CITY OF ALBUQUERQUE

Re: Proposed Uptown Site Grading and Drainage Plan
Engineer's Stamp dated 12-6-06 (J18/D33)

Re: Proposed Uptown Site Grading and Drainage Plan

Re: Proposed Uptown Site Grading and Drainage Plan
Engineer's Stamp dated 6-21-06 (J18/D33)

**12 TRASH ENCLOSURE**  
S-1 SCALE: 1/8"=1'-0"

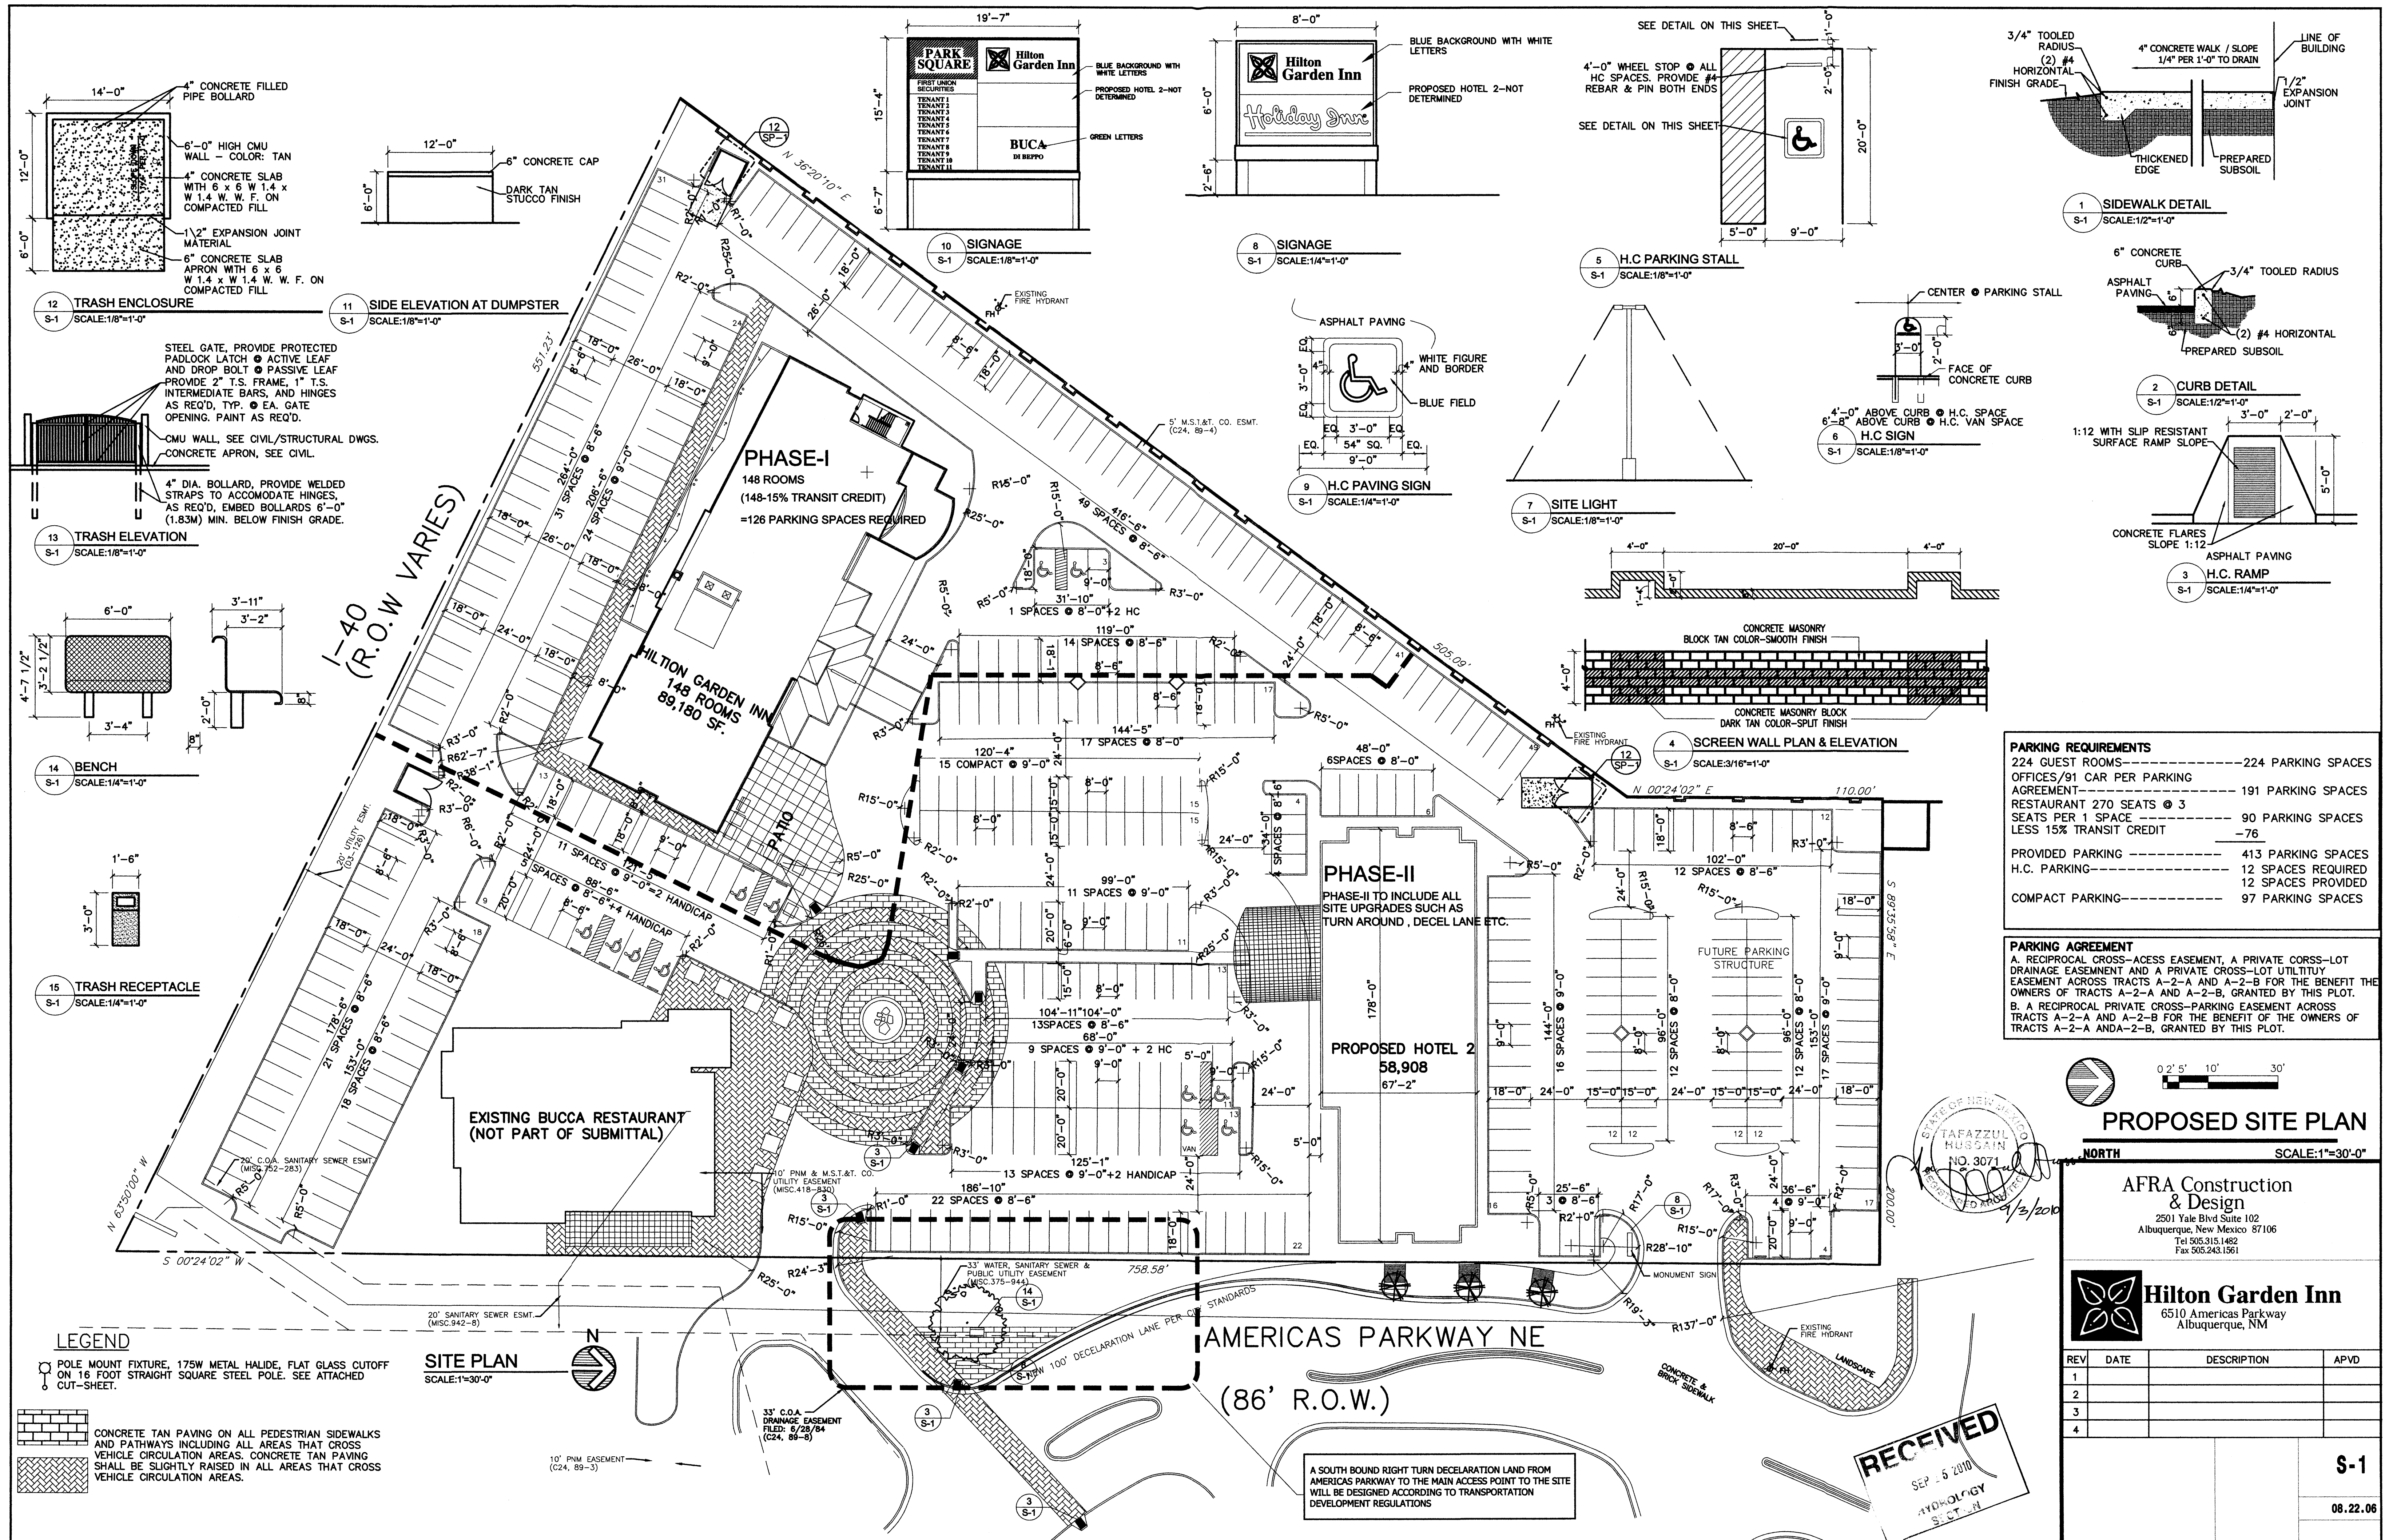
- The proposed dumpster enclosure near the future Holiday Inn needs to be relocated since it is in the runoff flow path.
- Dumpster enclosures need to be plumbed to the sanitary sewer system.
- Provide a detail for the concrete rundown area and address the ponding at the bottom of the concrete rundown.
- NJ* • There is no north arrow on the plan.
- NJ* • Please address offsite flows from all directions.
- NJ* • What does the dark line on the northwest edge of the property symbolize?
 - A section of the existing valley gutter is broken.

The proposed dumpster enclosure location is in the runoff flow path. This will have to be corrected to obtain Building Permit.

## GRADING PLAN Proposed Uptown Site ALBUQUERQUE, NM

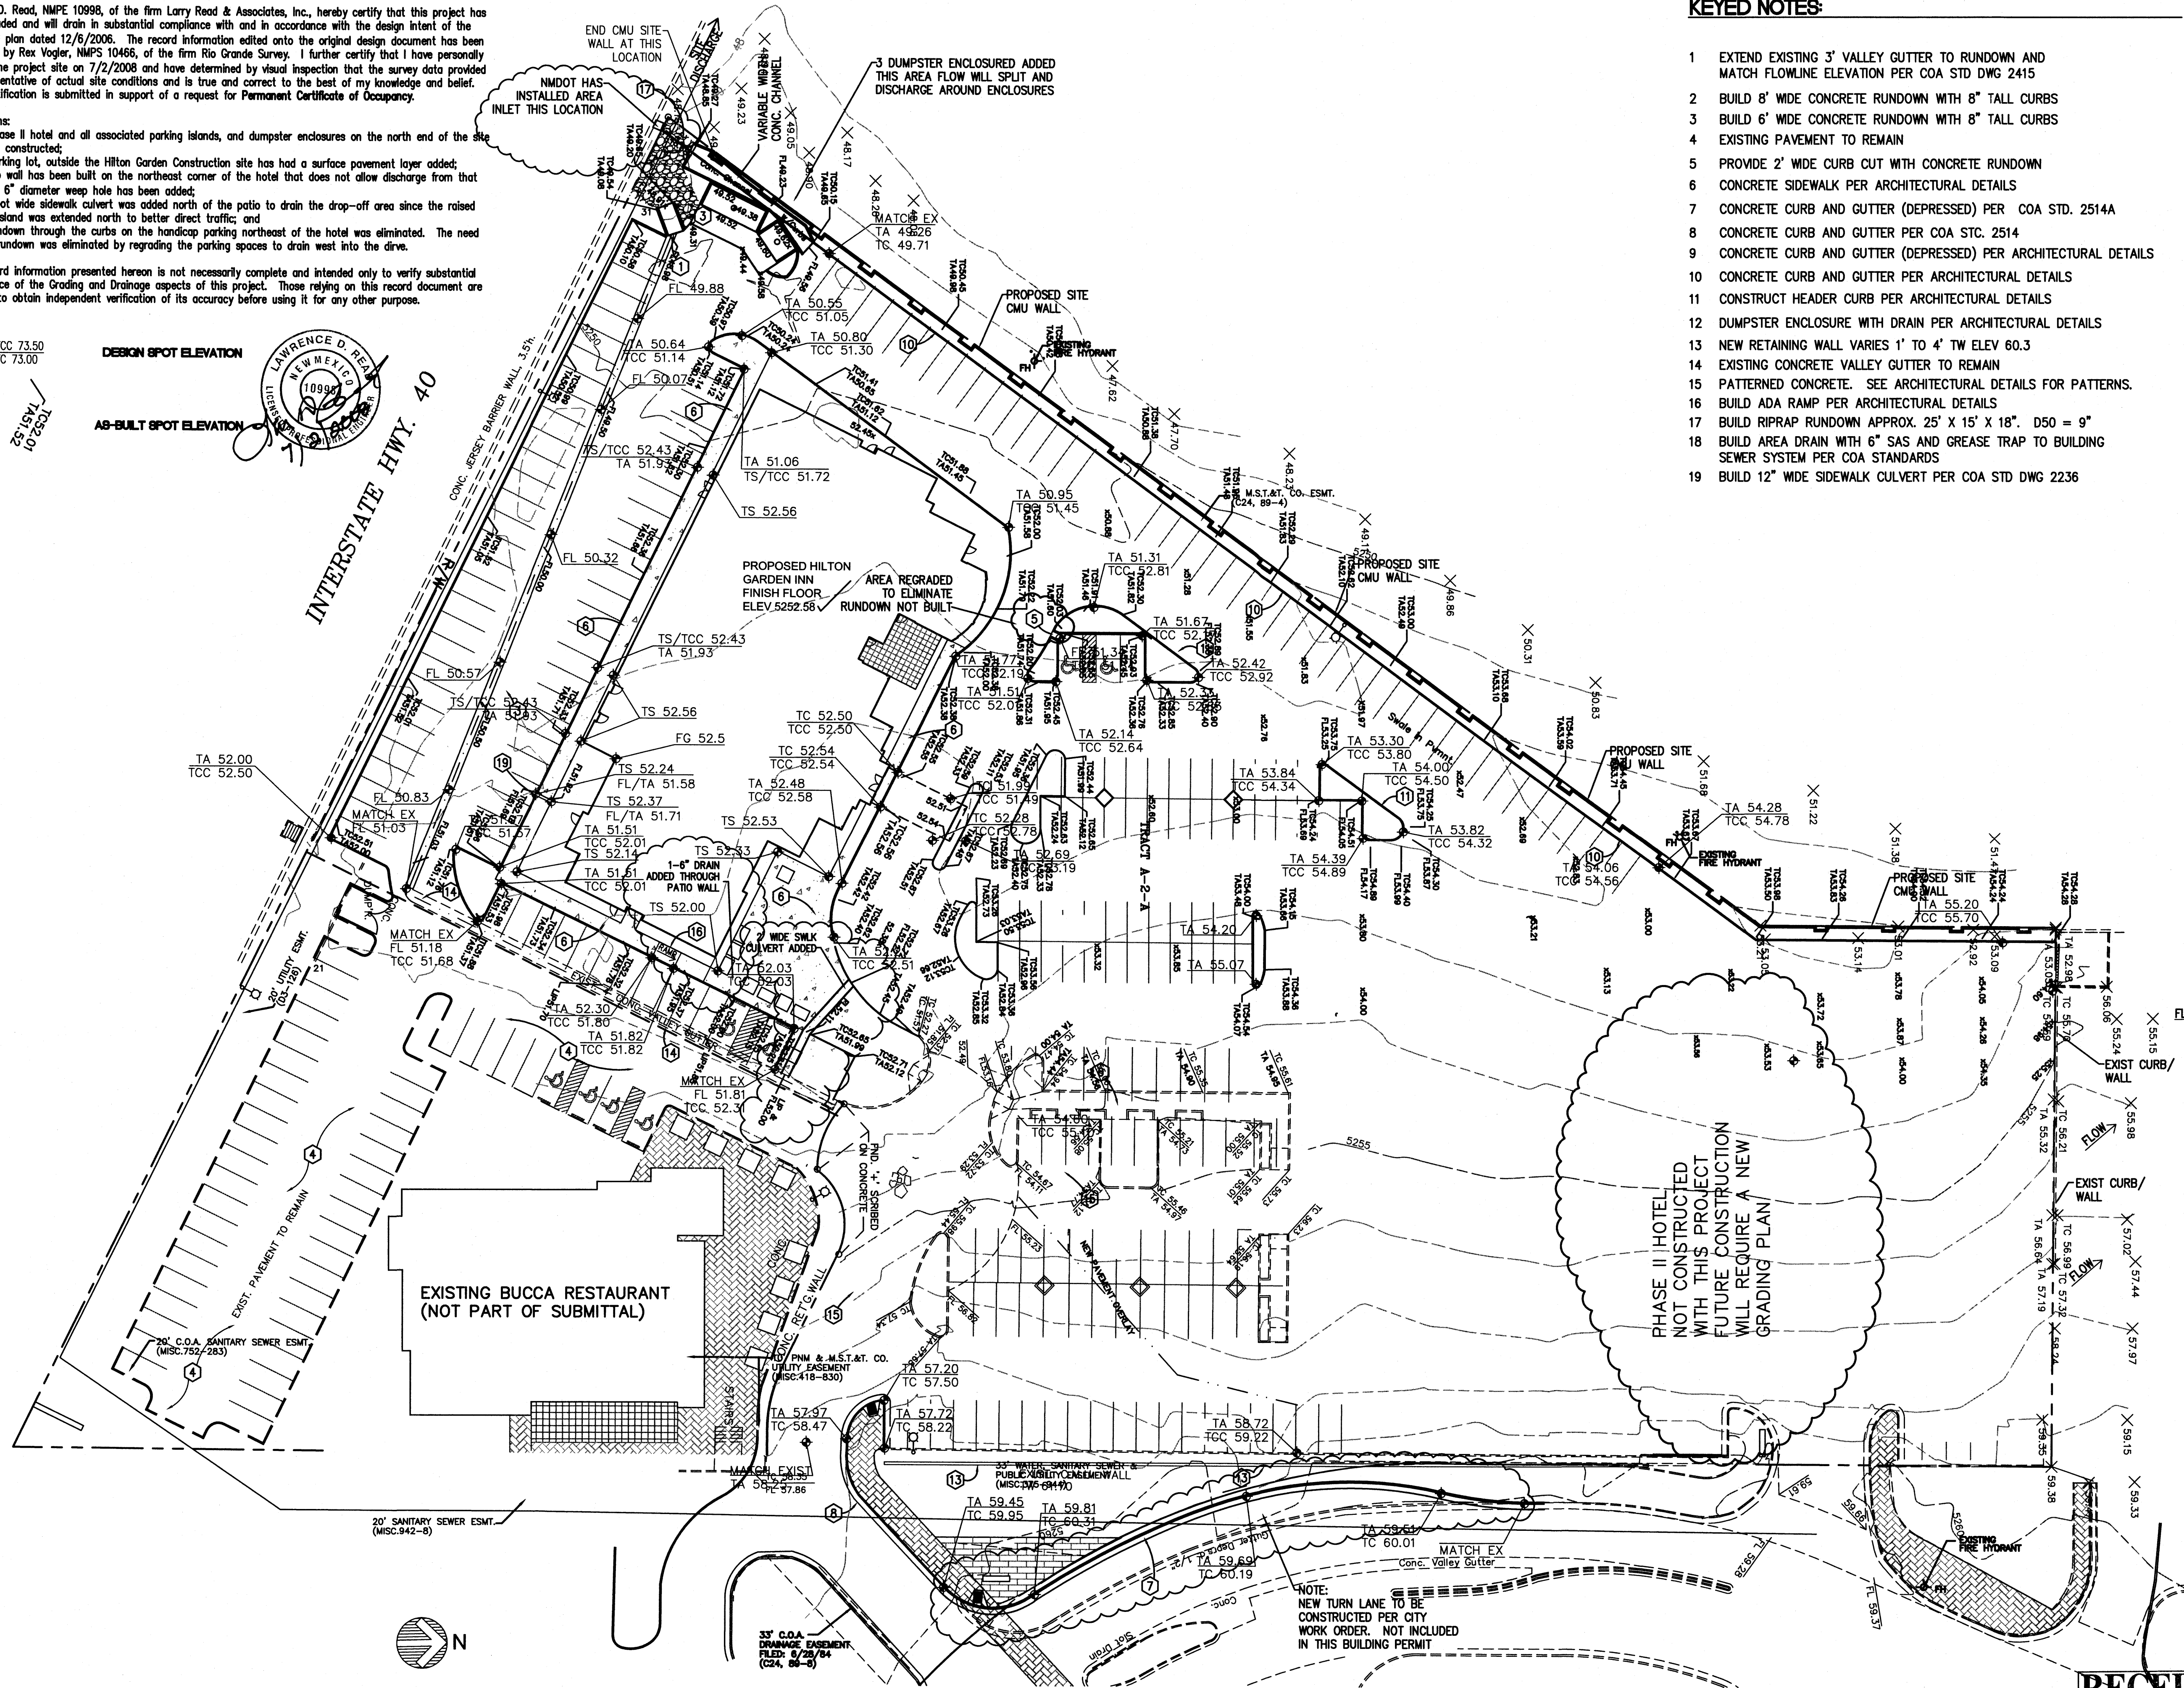
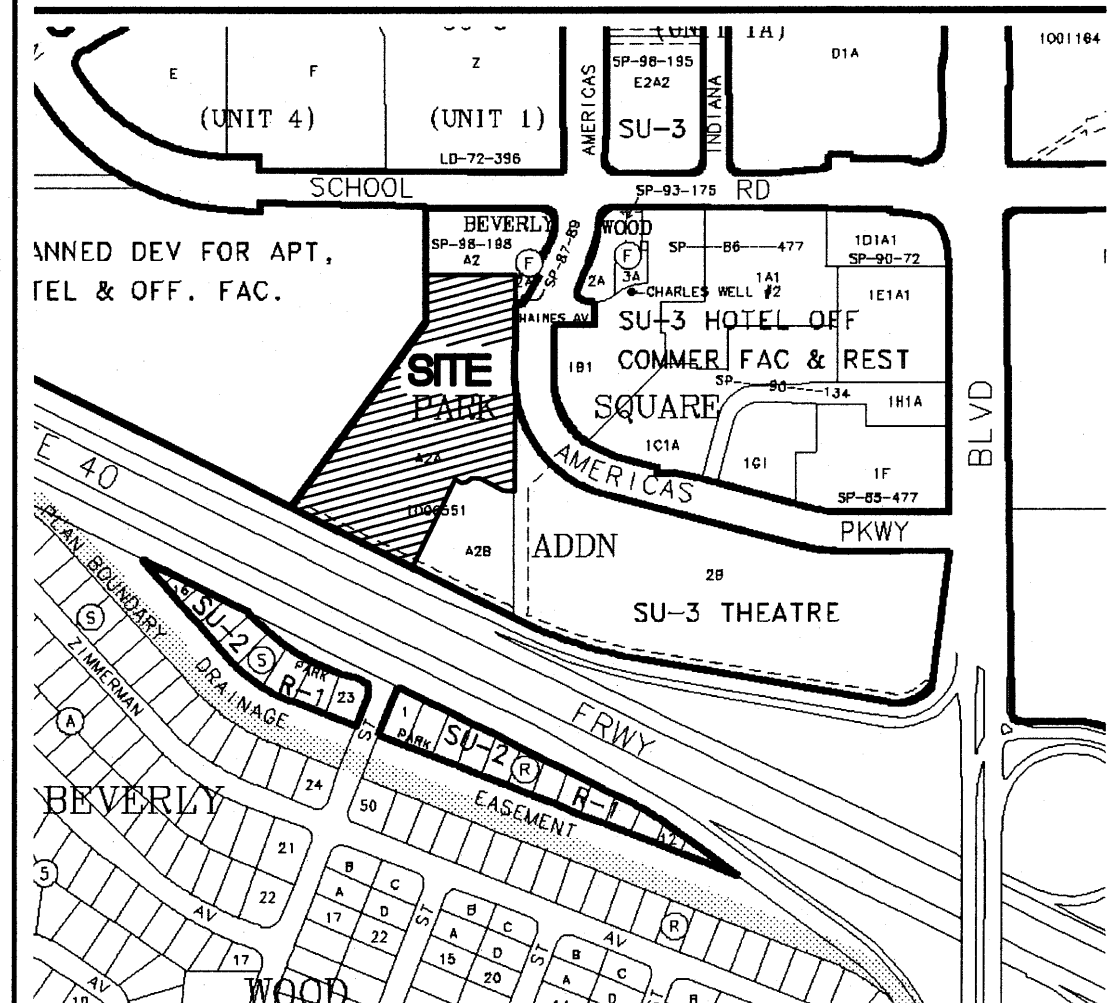
- There is no north arrow on the plan. ✓
- Please address offsite flows from all directions. ✓
- What does the dark line on the northwest edge of the property symbolize? *new wall - call out*

- Provide offsite elevations along the north and west property lines, flow lines at the drive entrances, and elevations in the earthen swale. *or show that w. keeps going w and N. enters*
- Runoff from this site enters the site to the west at the area of the rip-rap rundown. Design of this site should prevent this from occurring. *or better*
- Is that a ~~curb~~ on the downstream side of the rip-rap rundown? *call out* **OK**
- Is the TC=50.10 proposed spot elevation near the rip-rap supposed to be a TA=50.10? Also, notations in this area are cutoff by the calculation box. Move/resize the box so that it does not overlay the build notes.

- *Please show that curb work [7] is to be done by City work Order*
